EL PASO COUNTY PLANNING AND COMMUNITY DEVELOPMENT DEPARTMENT

GRADING AND EROSION CONTROL PLAN CHECKLIST

PCD File # PPR-22-044

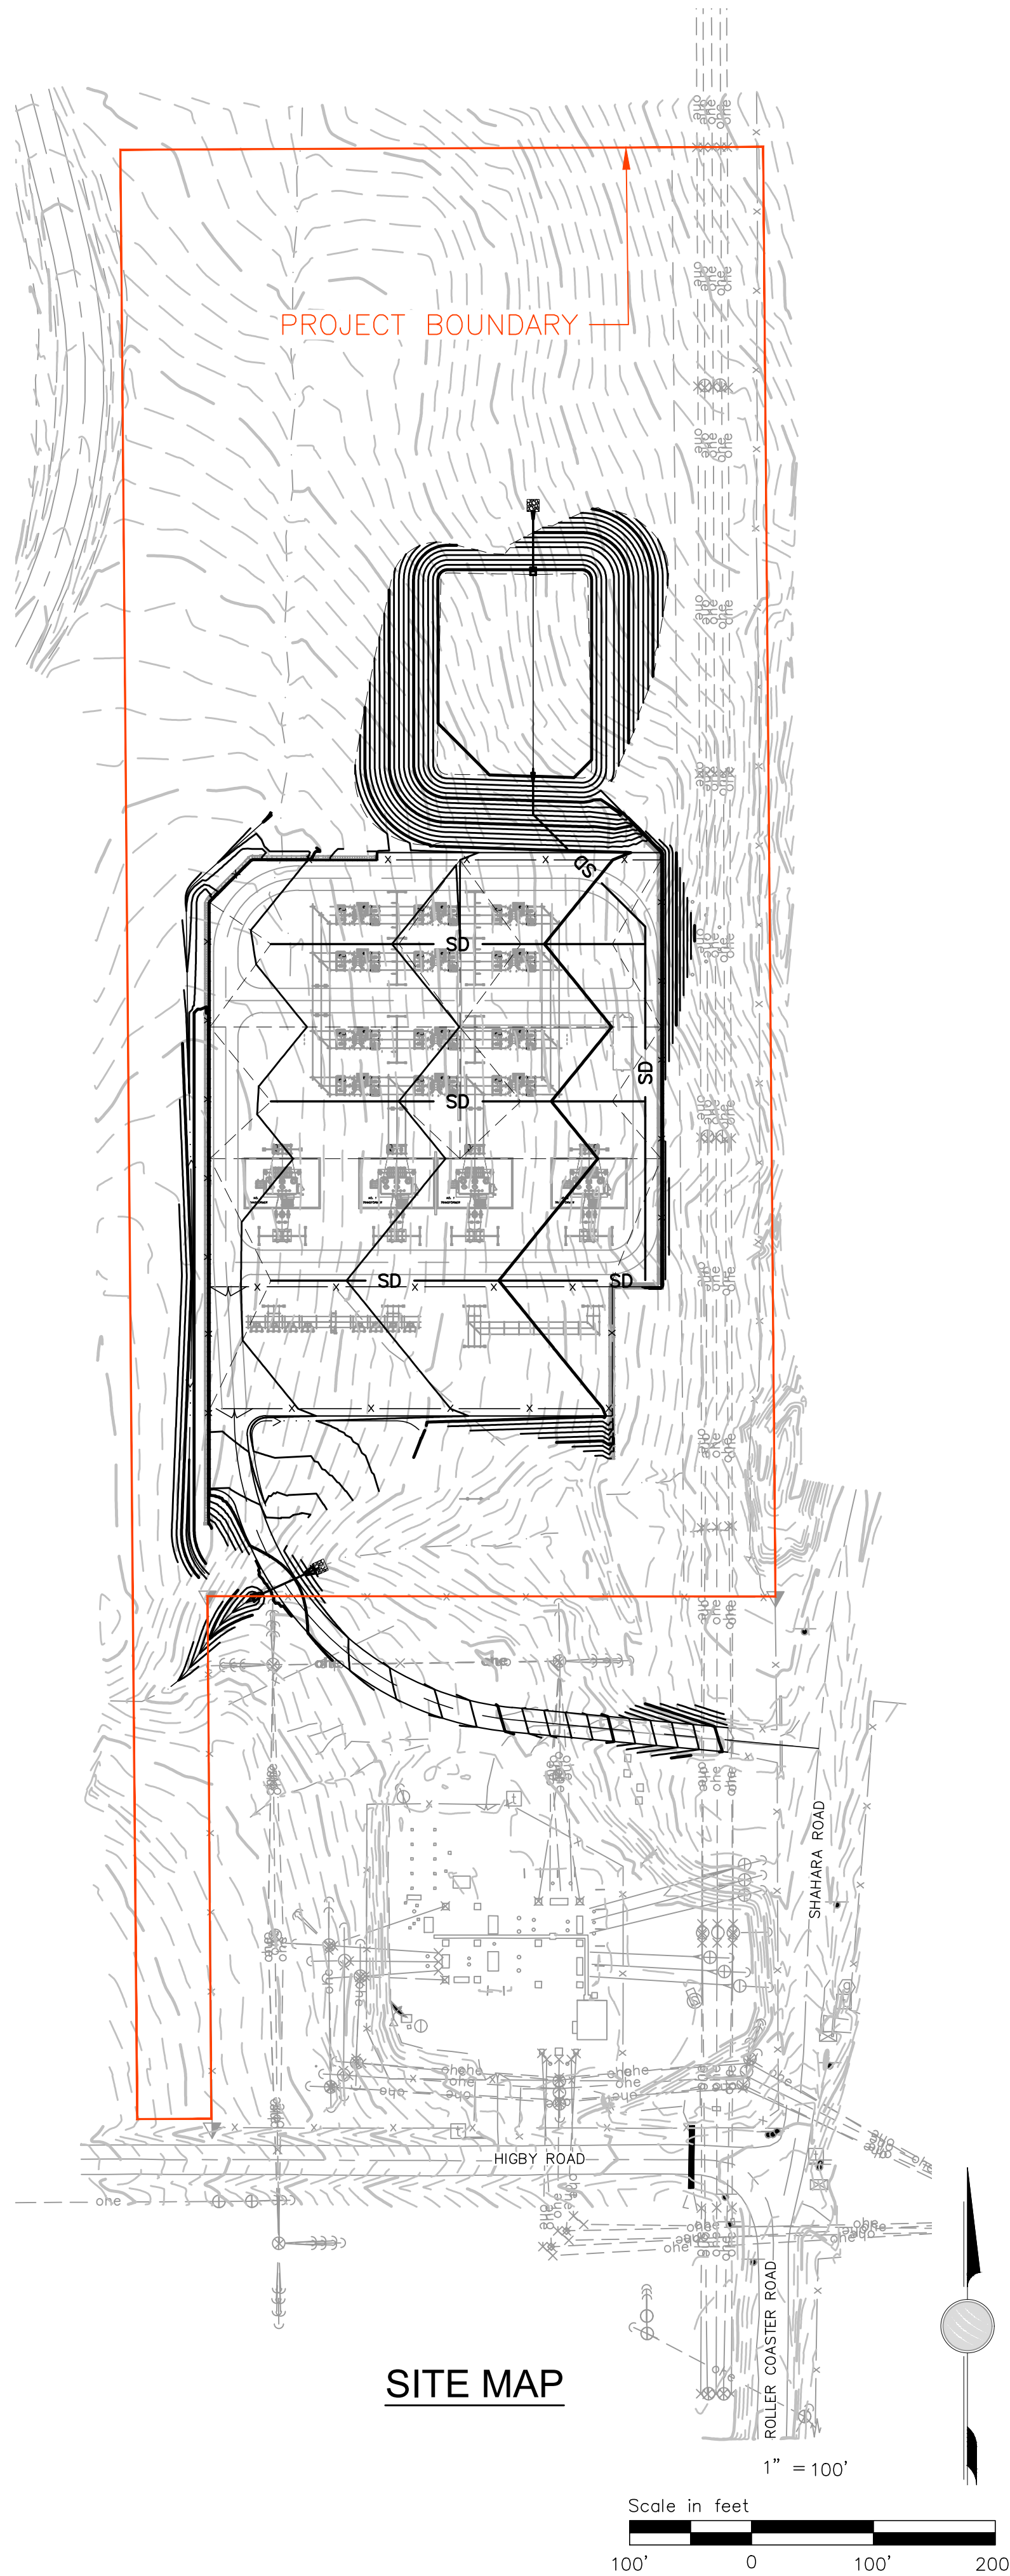
gg	Engineer's Statement (for GEC Plan within Construction Drawing set): These detailed plans and specifications were prepared under my direction and supervision. Said plans and specifications have been prepared according to the criteria established by the County for detailed roadway, drainage, grading and erosion control plans and specifications, and said plans and specifications are in conformity with applicable master drainage plans and master transportation plans. Said plans and specifications meet the purposes for which the particular roadway and drainage facilities are designed and are correct to the best of my knowledge and belief. I accept responsibility for any liability caused by any negligent acts, errors or omissions on my part in preparation of these detailed plans and specifications. <i>[Signature]</i> _____ Date <i>5/6/2022</i> Engineer of Record Signature		N/A
hh	Owner's Statement (for standalone GEC Plan): I, the owner/developer have read and will comply with the requirements of the Grading and Erosion Control Plan. _____ Date _____ Owner Signature missing signature on GEC plan		X

missing signature on GEC plan
